**From:** webmaster@ribblevalley.gov.uk  
**Sent:** 06 July 2020 13:05  
**To:** Planning  
**Subject:** Form completion: Planning Application Comments Form

**title:** [REDACTED]  
**LastName:** [REDACTED]  
**firstName:** [REDACTED]  
**numberName:** 2 Bradley Court  
**postAddress:** 2 Bradley Court Thornley Road Chaigley Clitheroe  
**postCode:** BB7 3LY  
**refNo:** 3/2020/0344  
**addDev:** 3 Bradley Court Thornley Road Chaigley Clitheroe BB7 3LY

**From:** [REDACTED]  
**Sent:** 06 July 2020 13:06  
**To:** Planning  
**Cc:** [REDACTED]  
**Subject:** PLANNING CONSULTATION 3/2020/0344 3 BRADLEY COURT CHIPPING BB7 3LY  
**Attachments:** Comments 3-2020-0344.docx

4 Proposed Side (south) Elevation  
1 : 100

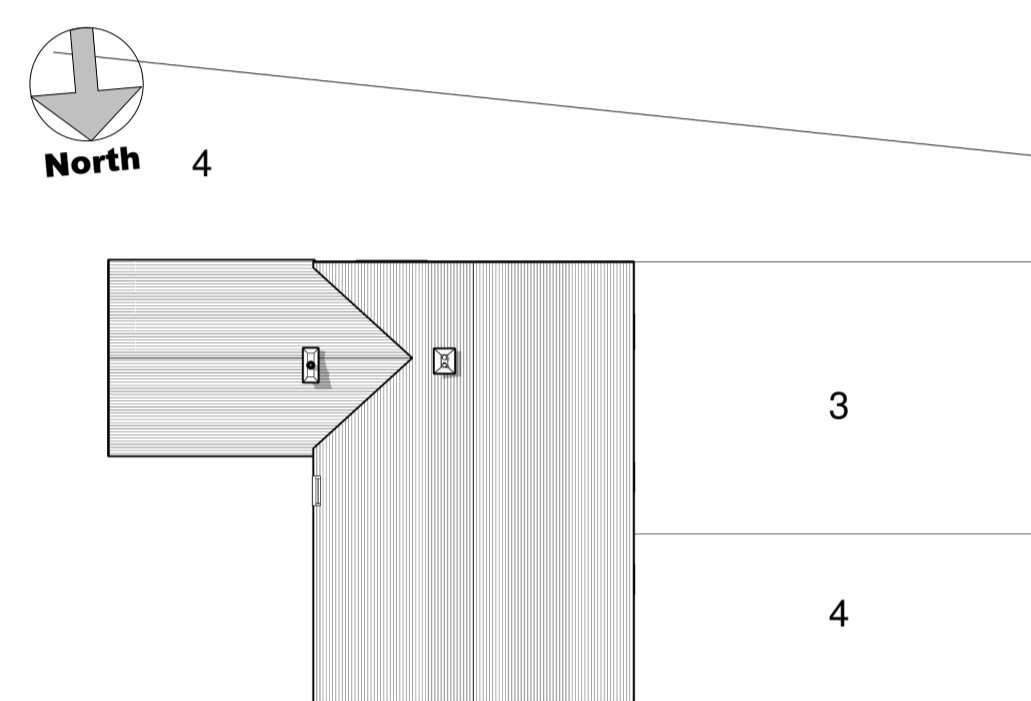
2. The planning application for the addition of two extra windows to the gable end (south, side elevation) of No.3 will have a significant impact on the scale, appearance and design of the original barn wall and its wealth of historic features. The roof light and French doors are not in keeping with any of the other 8 properties, there are no other roof lights and all properties have single half glazed doors therefore, this will have a visible impact on the roof line, the look and feel of Bradley Court and an impact on the character of the area.
